Culbone
The Leys
Adderbury
Banbury
OXON
OX17 3ES

11 January 2020

Planning Application No. 19/02691/F - 3 new dwellings in The Leys, Adderbury

Client	Mrs Biggam	Project	PROPOSED DEVELOPMENT OF LAND AT THE LEYS ADDERBURY	Drawing	PROPOSED FLOOR PLANS PLOT 1
Architect	Nicholas D Price 45 North Bar Street Banbury OX16 0TH Tel 01295 262952			Scale	1:100
				Drawing No	5392.03

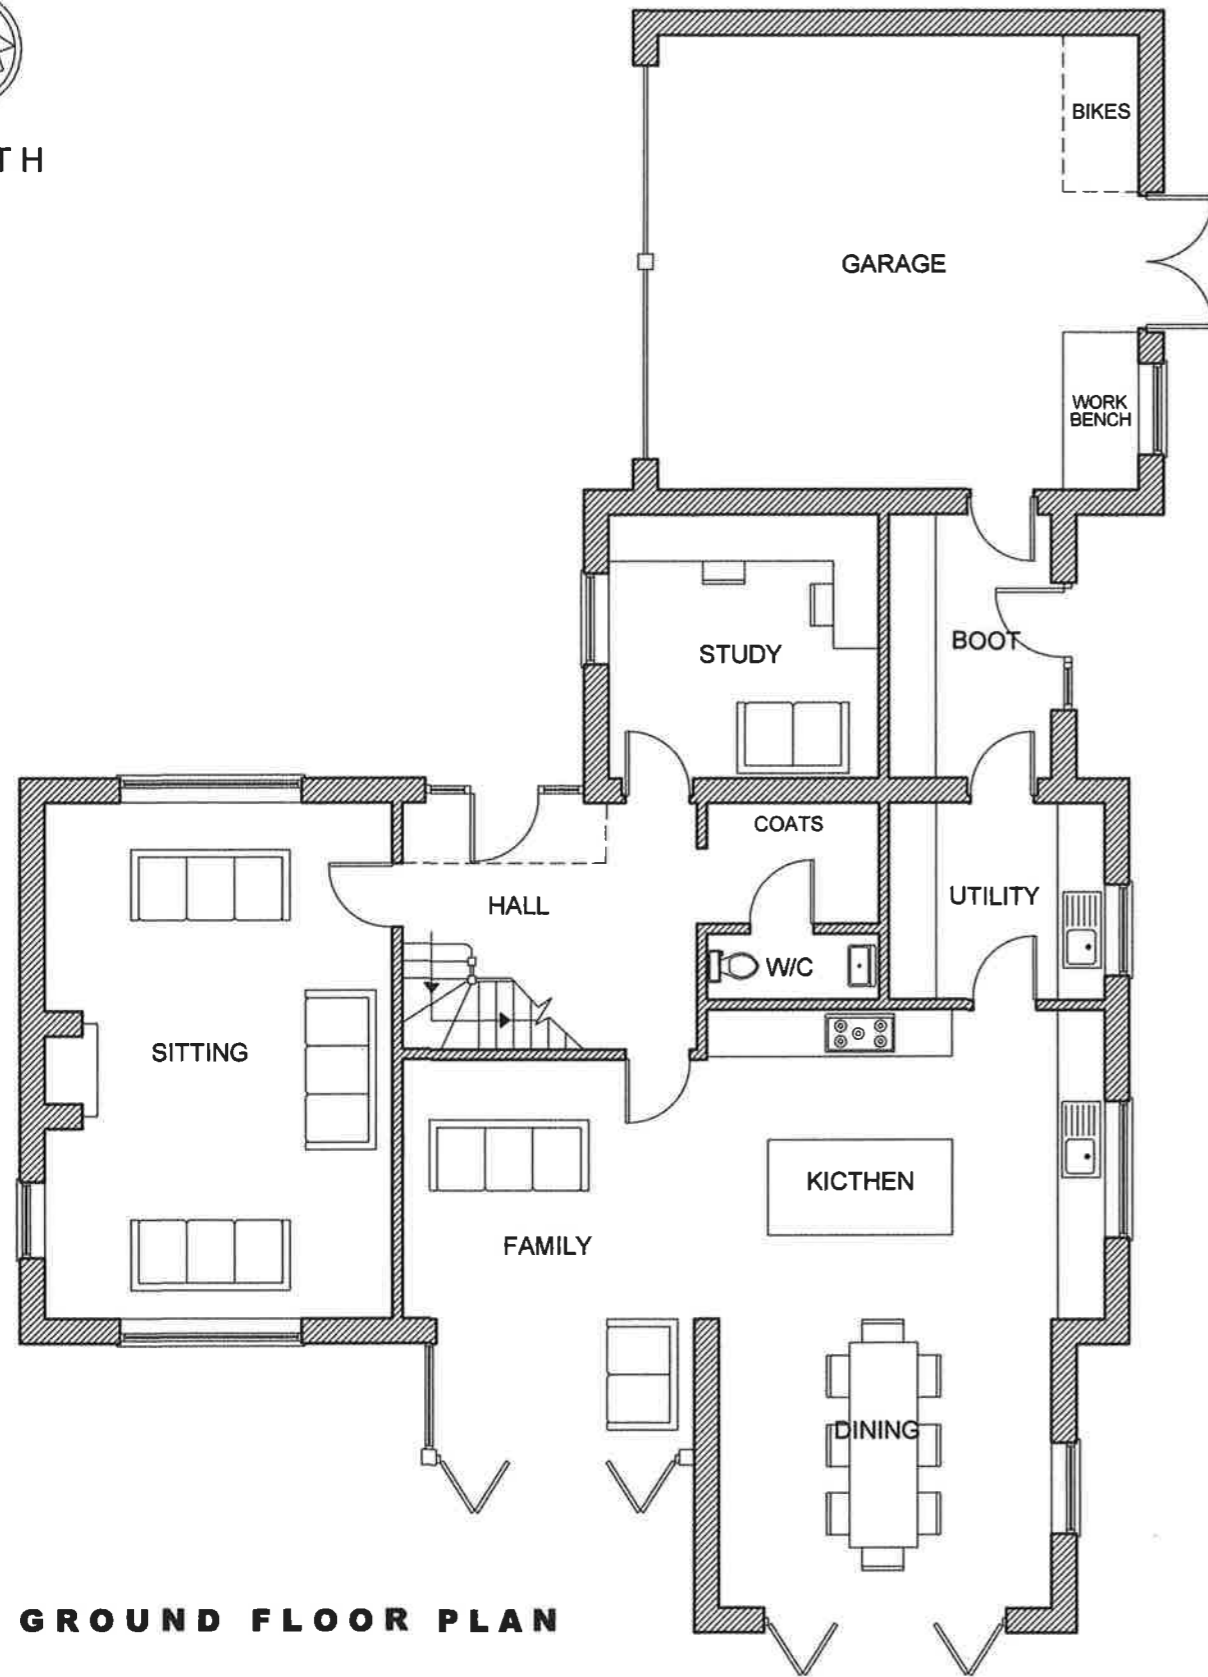
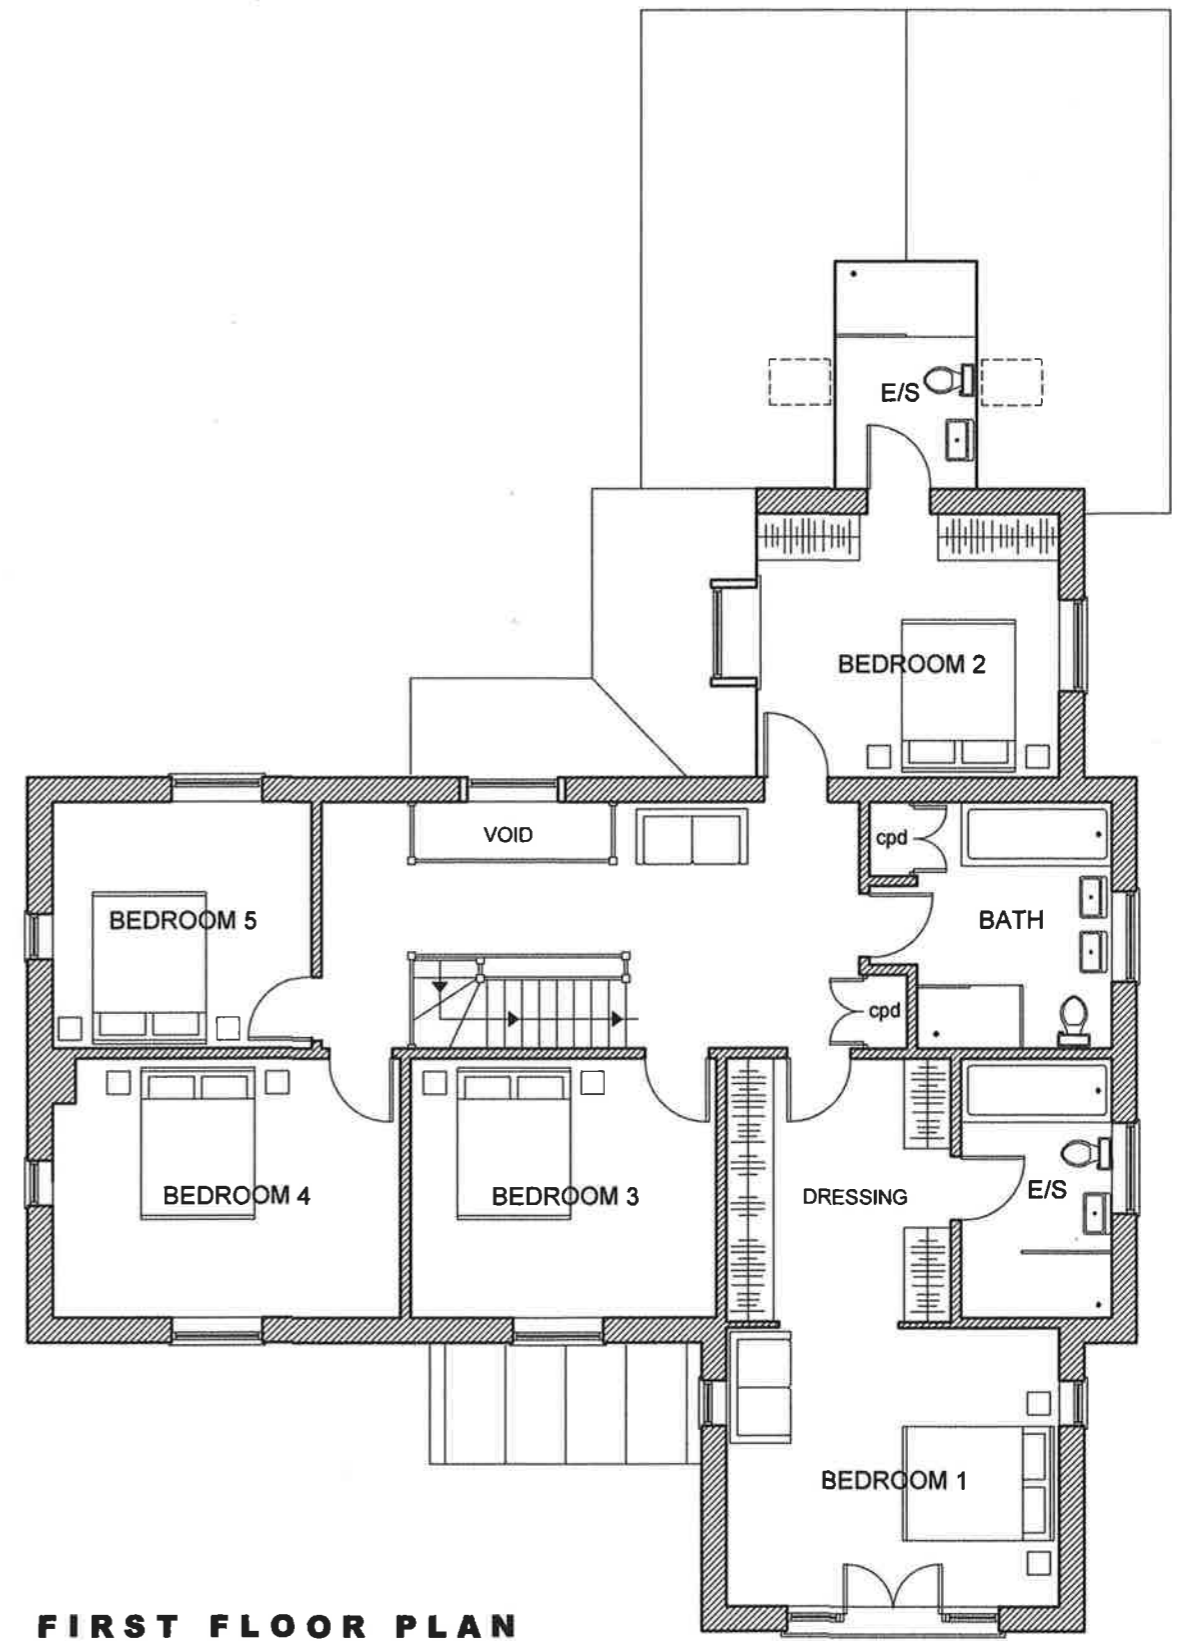
Oak tree's have an extensive root system spreading horizontally, this lateral mass of roots bring the tree moisture and nutrients for its lifetime. Most oak tree roots lie only 18 inches under the soil, they spread to occupy a space four to seven times the width of the tree's crown. The plans only show protection of the area directly under the canopy (or crown) of the tree and does not allow for the fact that roots will undoubtedly be across the whole area of the proposed Plot No.1.

Client	Mrs Biggam	Project	PROPOSED DEVELOPMENT OF LAND AT THE LEYS ADDERBURY	Drawing	SITE LAYOUT PLAN
Architect	Nicholas D Price 45 North Bar Street Banbury OX16 0TH Tel 01295 262952		Scale	1:500	Date
		Drawing No	5392.02	# # #

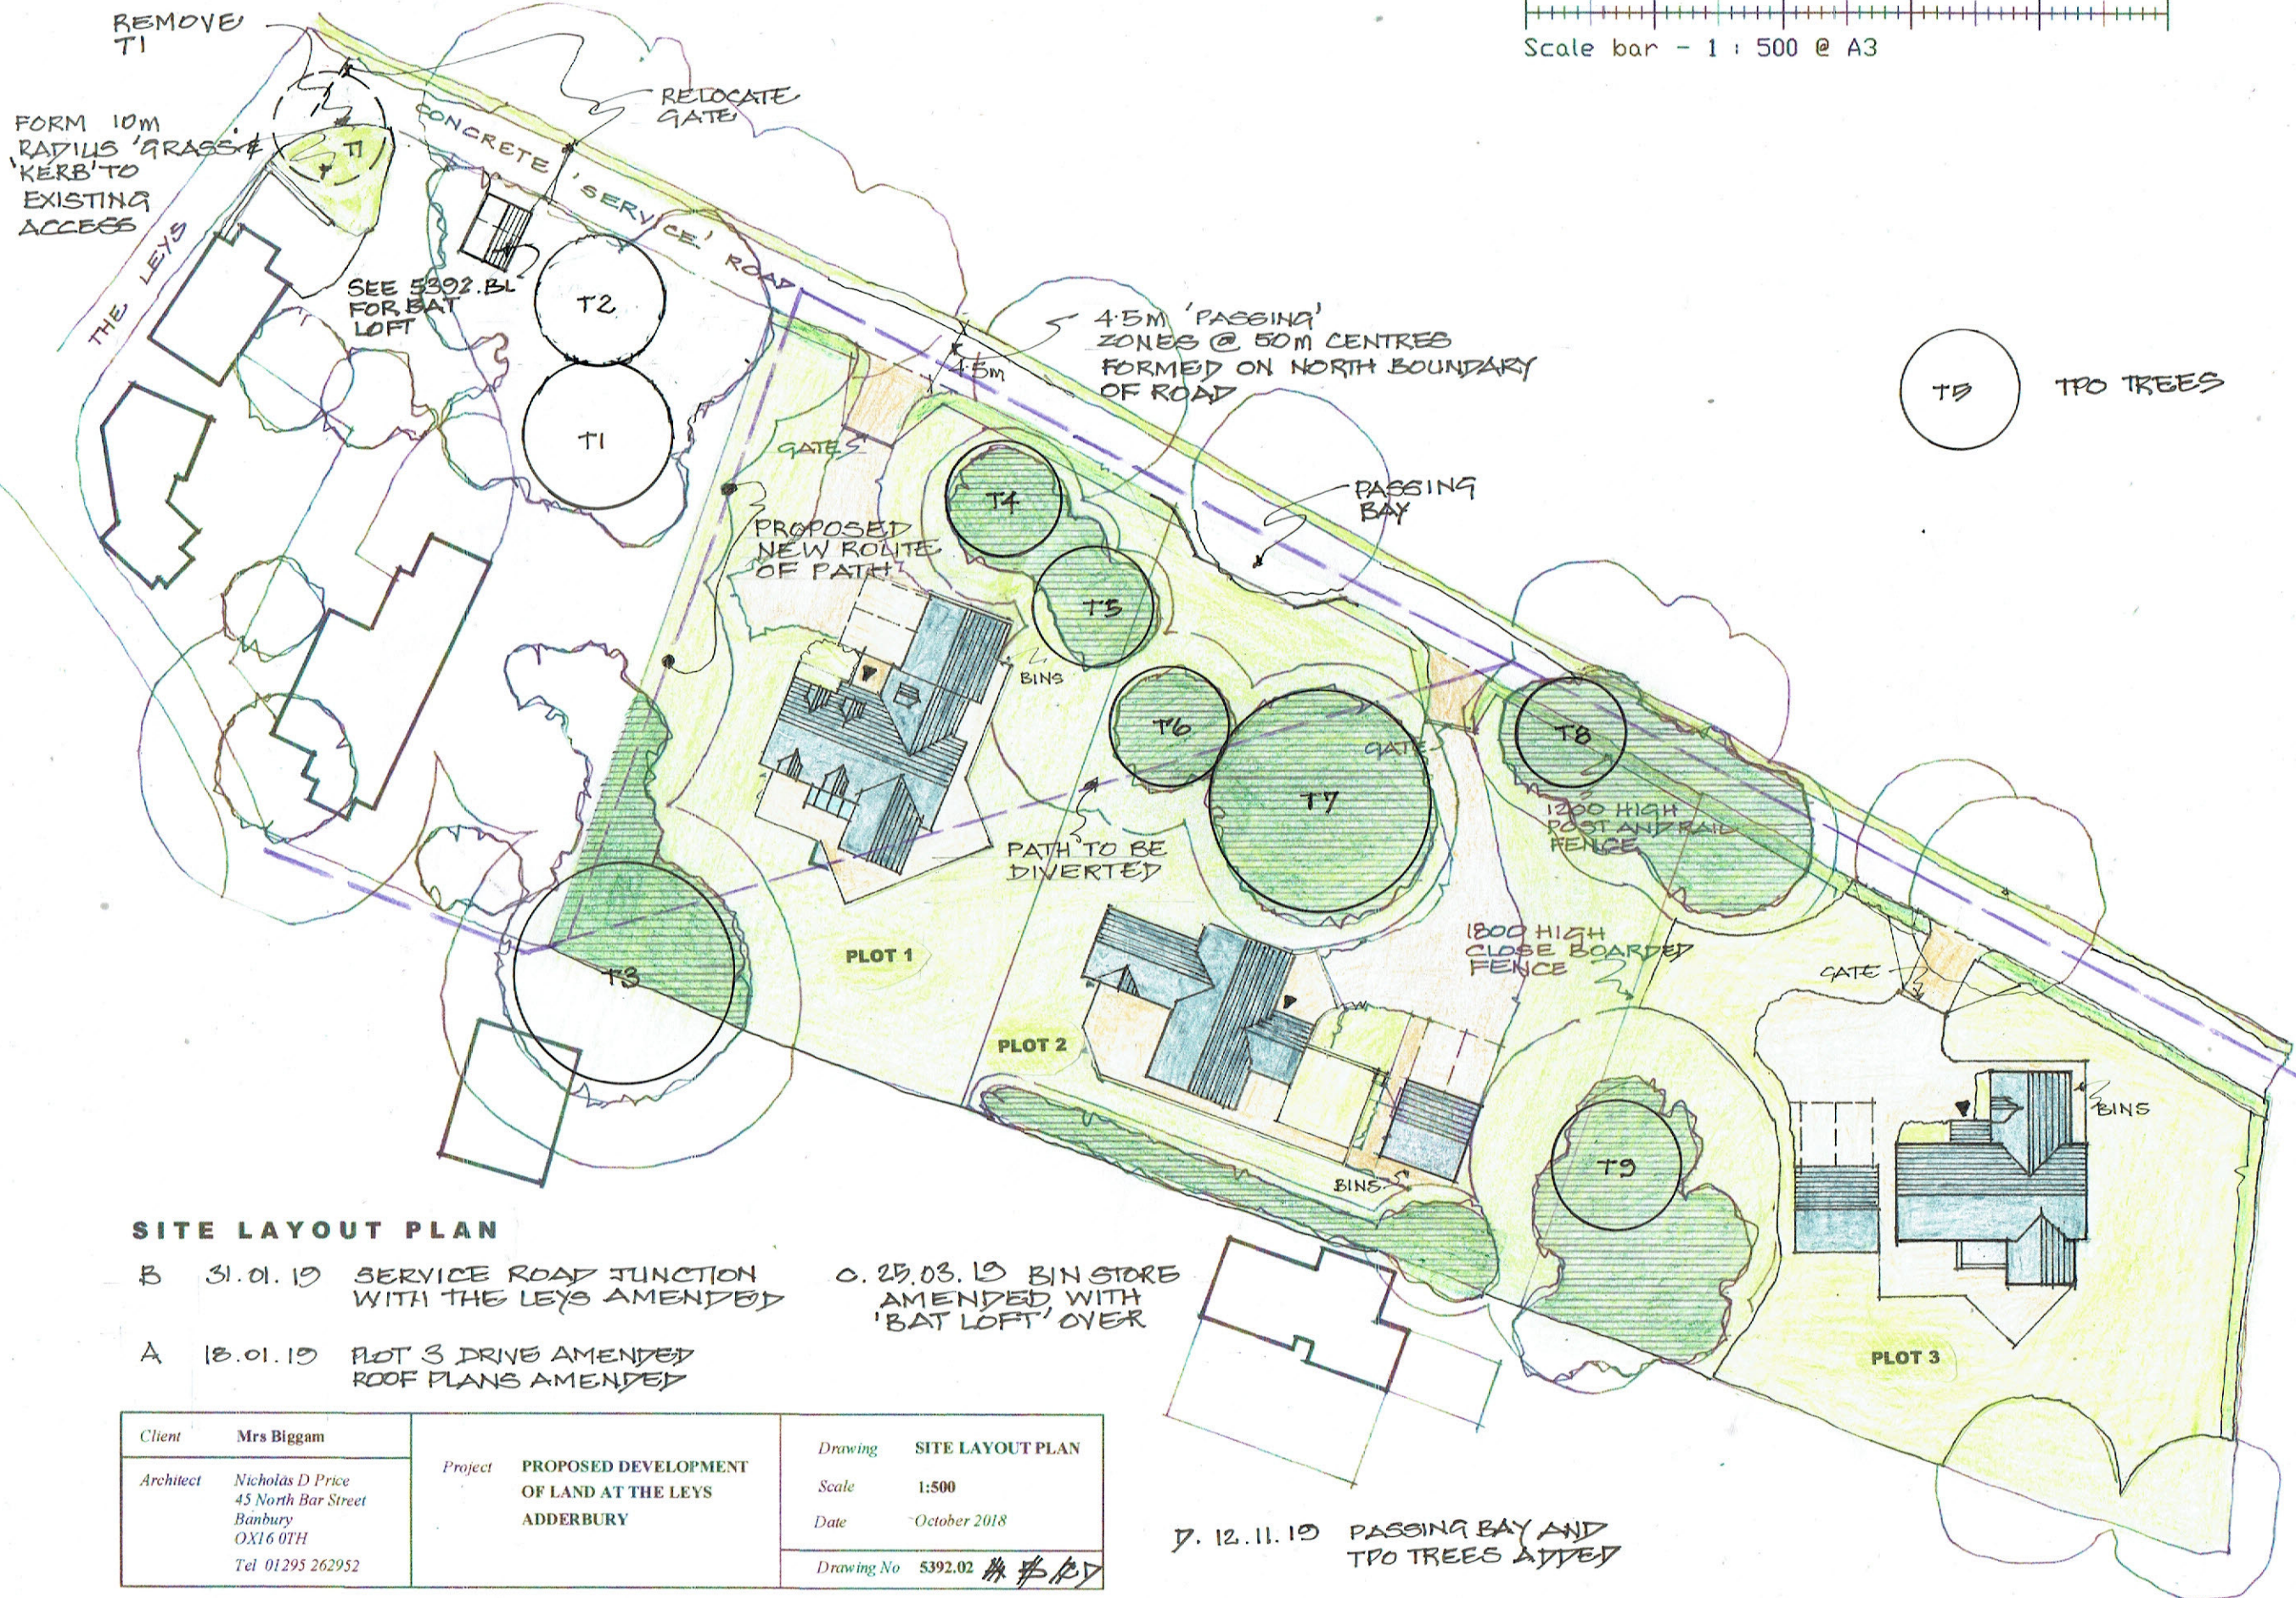
The other amendment to this original application, for a simple passing place on the concrete service road, is in no way going to alleviate traffic concerns. Access to the proposed development remains via The Leys, a narrow single track lane. The surrounding roads are very narrow too and often congested with a lot of on street parking. There are no footpaths in Tanners Lane or The Leys and this is a popular and well used route for dog walkers and families with small children, walking to The Lucy Plackett playing-field, as well as walkers accessing other village footpaths and residences. Vehicles meeting on these lanes often have to reverse to pass and at times it is necessary for pedestrians to climb grassed banks to allow vehicles to drive by. Bearing this in mind, does it really make sense to increase the traffic to The Leys by another 6-12 cars (from 3 large family houses) and that is without even considering the impact of any development construction traffic? The large Plant and equipment necessary to clear this difficult to access site, together with general construction vehicles and multiple building materials deliveries will be unbearable for existing local residents. This is contrary to point 6.4 in the Planning Statement November 2019 prepared by Framptons which glibly states that "The proposed development will have no impact on the amenity of occupiers of neighbouring properties".

The 'neglected' garden as it is described is full of diverse beautiful trees and plants which could have been maintained better and would potentially need to be ripped out and destroyed to facilitate this proposed development. Some trees are now subject to Tree Preservation Orders but the application does not appear to have considered the full extent of the root system of the Old Oak Tree - marked as T24 on the Apical Arbor Tree Plan diagram, its trunk sitting within our property boundary.

It may be a thoughtful concept to combine a bin collection area with a bat loft, however, in reality it will struggle to work because bin lorries will not go on to private land, hence multiple bins would doubtless end up having to be put at the end of the concrete service road where it joins The Leys. So on weekly collection days, a further 3-6 or even more bins could be on that junction in front of a very pretty listed thatched cottage and more worryingly create yet more traffic hazards! There is simply no space for bins here without causing obstruction and to say this would be only one day a week puts the onus firmly on all homeowners returning bins promptly post emptying and not leave them out for several days before or after collections. Furthermore leaving them out overnight - in a poorly lit narrow lane - is likely to create additional obstacles for access by existing residents.
